**Deadline 2 Representations**

## A14 Cambridge to Huntingdon Improvement Scheme

Representation No. 502

From Michael Alexander. FRICS. FAAV on behalf of Messers John and James Witherow

Drawing title: **LAND PLANS REGULATION 5(2)(i) SHEET 18 OF 40**

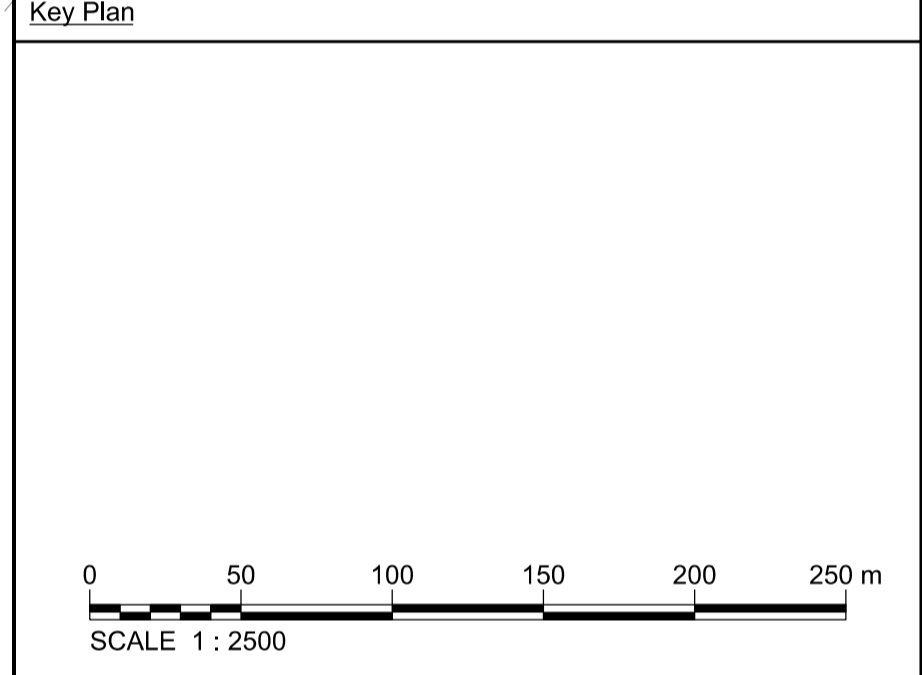
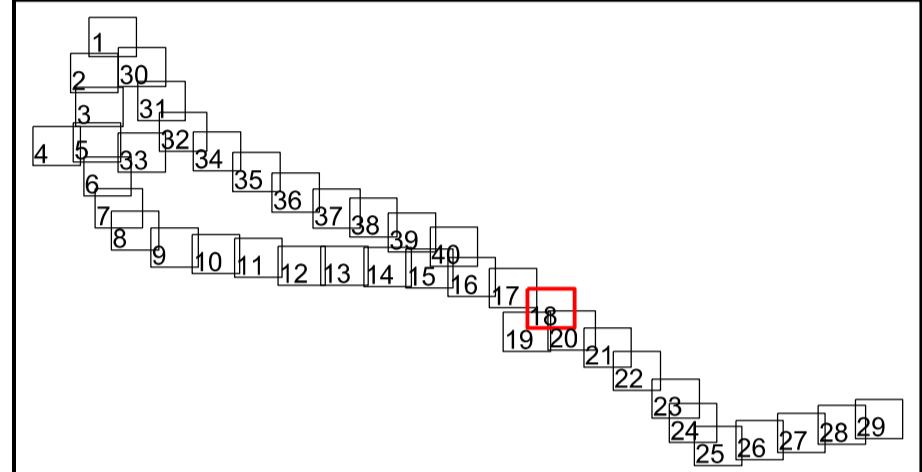
1. Our clients currently occupy 100ha on a Farm Business Tenancy known as Brickyard Farm at Boxworth. Of the overall area some 28ha are affected by proposals. Our clients note that in addition to plots 18/6a, 18/6b, 18/6c, 18/6d and 18/6e they are also in occupation of plots 18/5a, 18/5b, 18/5c and 18/5d on sheet 18 of the Land Plans.
